CITY OF ALBUQUERQUE

**Re: 2500 Carlisle Development
2500 Carlisle Blvd. NE
Traffic Impact Study, HT#H17D002A
Report dated November 2021
Engineer's Stamp -----
Via email jkruse@lee-eng.com**

The subject Traffic Impact Study received on November 12, 2021, has been reviewed by the City of Albuquerque Planning Development Transportation Section. The City finds the TIS acceptable and is approving the report with the following requirements.

Figure 2. Overall Site Layout

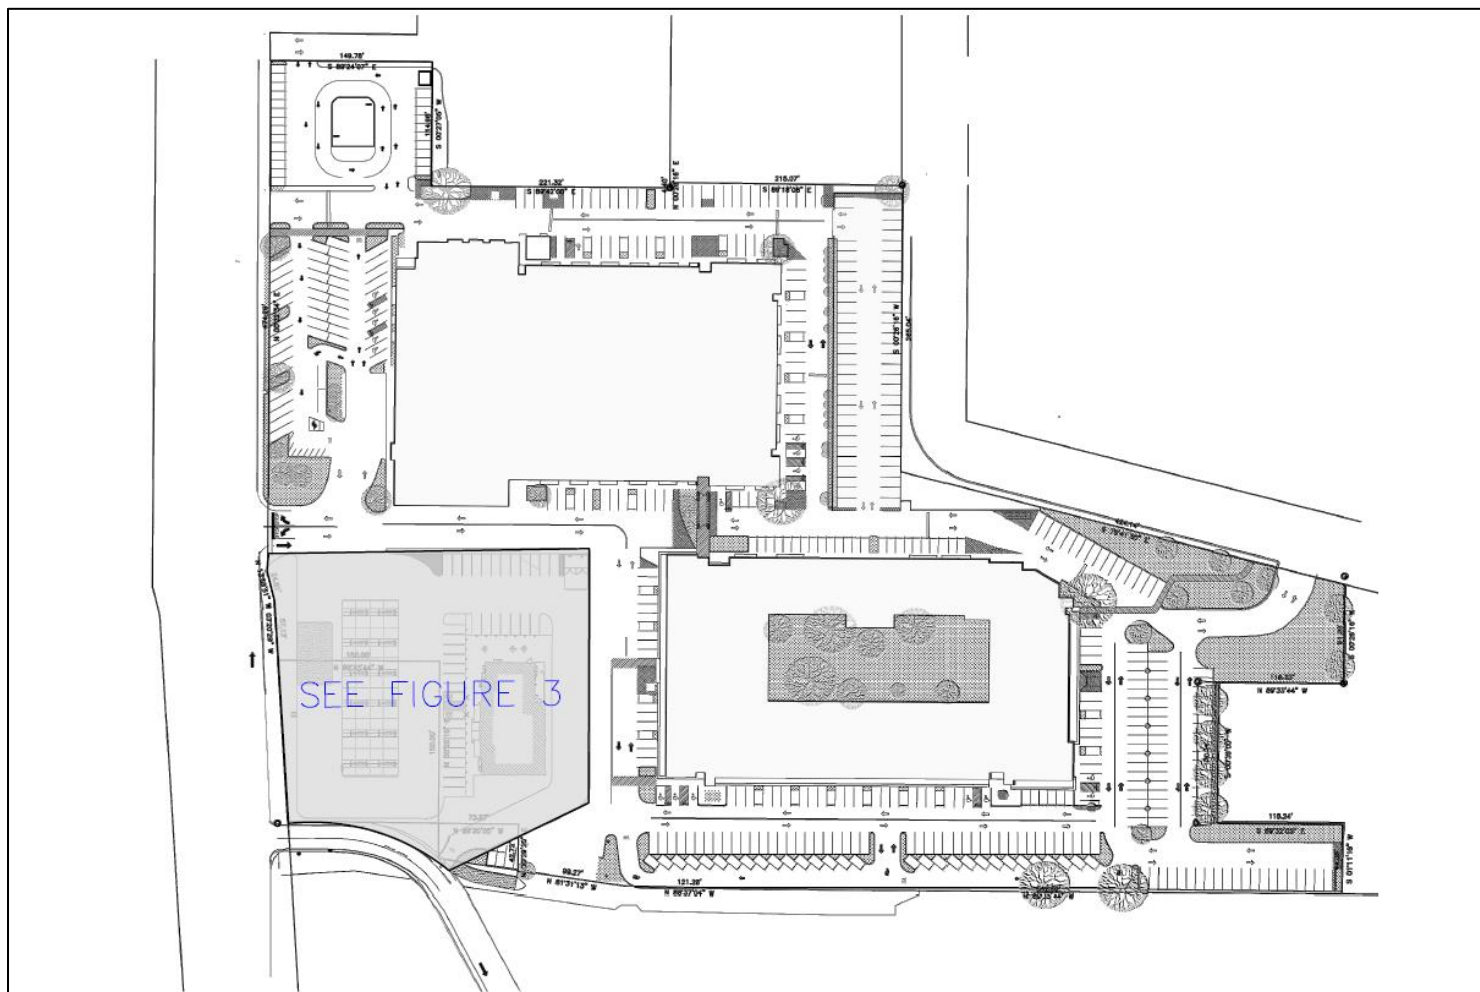
3. North Driveway 1 (shared easement with existing development to use for fast-food restaurant)
 - Right turn auxiliary lane is recommended. The 11-foot wide auxiliary lane length shall be 250 feet plus the 300'-150' radii transition.

- Driveway reconstruction with CABQ required curb returns.
4. North Driveway 2
 - Close North Driveway 2 to meet CABQ required driveway spacing and provide adequate deceleration length for the auxiliary lane at the driveway to the north.

5. South Full Access Driveway 3 (Prospect)
 - Right turn auxiliary lane is recommended. The 11-foot wide auxiliary lane length shall be 250 feet plus the 300'-150' radii transition.

- Driveway reconstruction with CABQ required curb returns.
 - Existing landscape concrete wall on both sides of the driveway entrance connects to curb return and presents pedestrian access and safety issues. It is recommended to remove the existing landscape wall and reconstruct curb ramps, sidewalks, and landscaping to accommodate ADA compliance.
